RE: **Lot 15 Block 2 Unser Cliffs SAD 227**
6912 Rimrock NW
Grading and Drainage Plan
Engineers Stamp Date 7/16/17 (D10D009)

Based upon the information provided in your submittal received 7/17/17, this plan cannot be approved for Grading Permit until the following comments are addressed.

ENGINEER'S SEAL  7/18/17 7/16/17 DAVID SOULE P.E. #14522	6912 RIM ROCK	DRAWN BY WCWJ
	GRADING AND DRAINAGE PLAN	DATE 7-15-17
	 Rio Grande Engineering 1606 CENTRAL AVENUE SE SUITE 201 ALBUQUERQUE, NM 87106 (505) 872-0898	21764-LAYOUT-7-14-17
		SHEET # — JOB # 21764

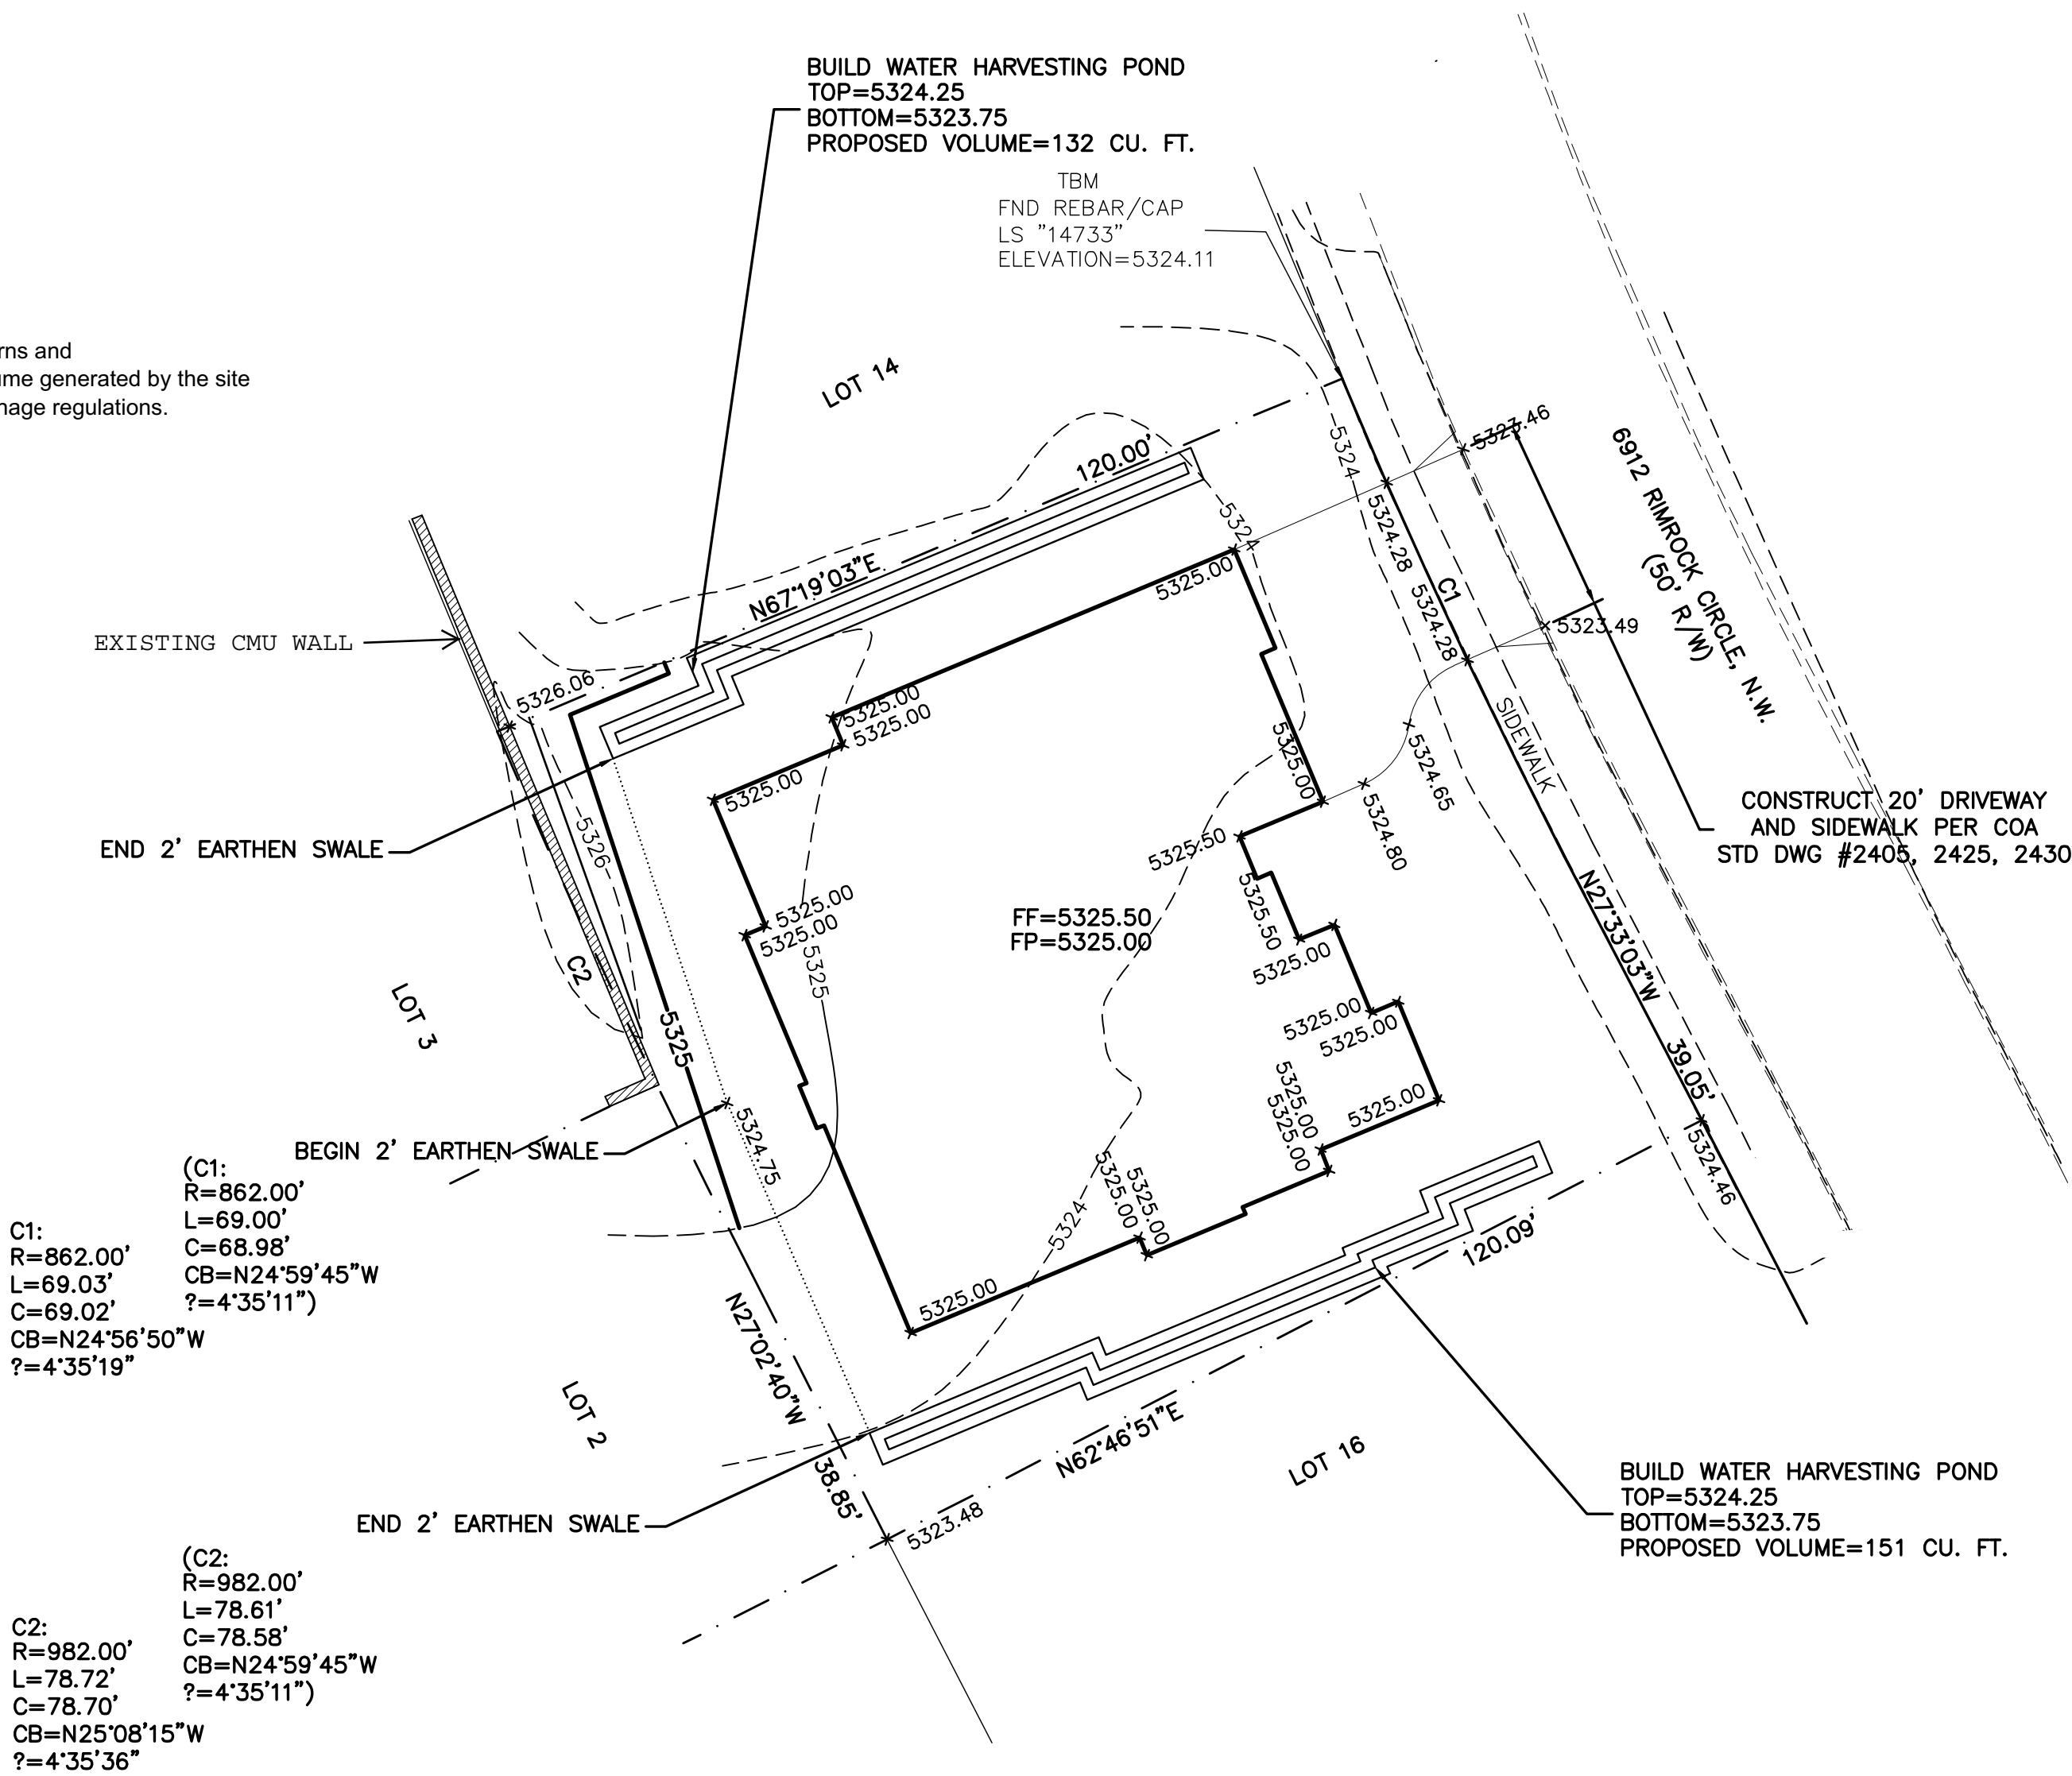
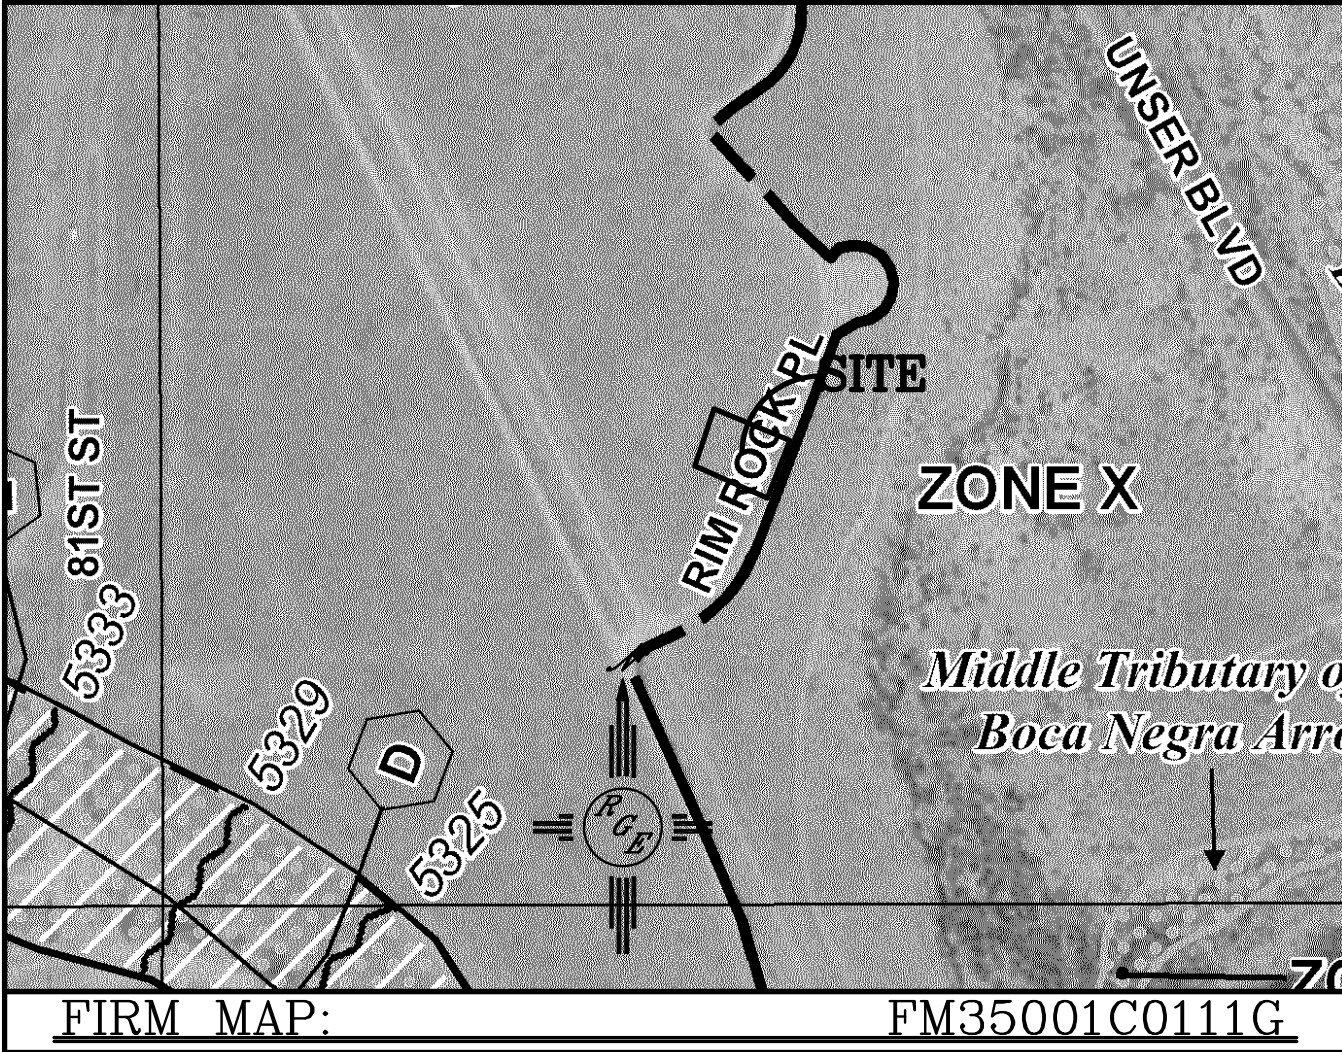
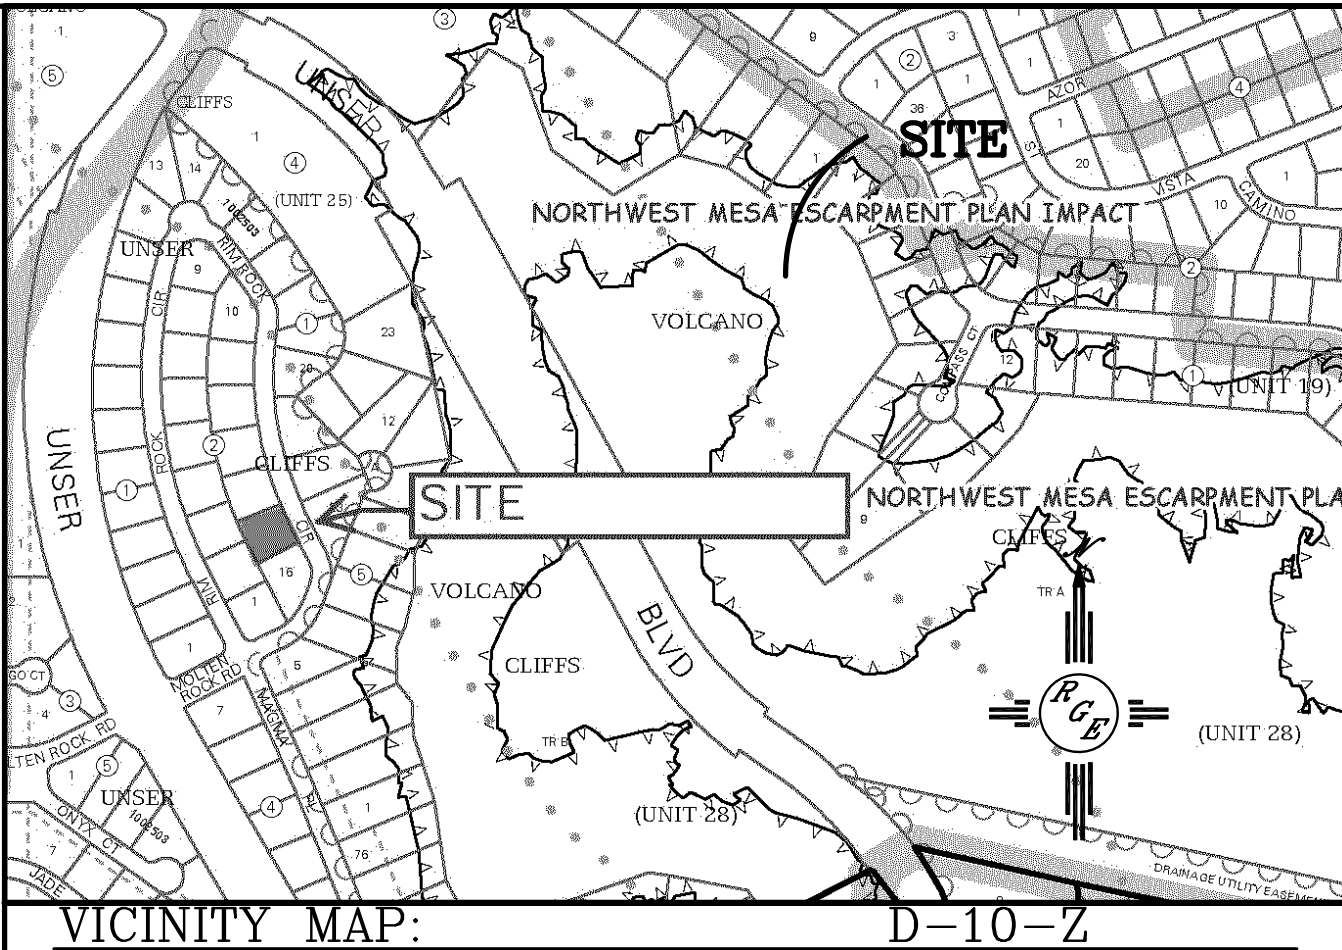
- Provide a statement on the plan stating that this grading plan must be used for the application of any garden/retaining walls.
- Provide a statement that a Pad Certification is required before building permit can be approved.
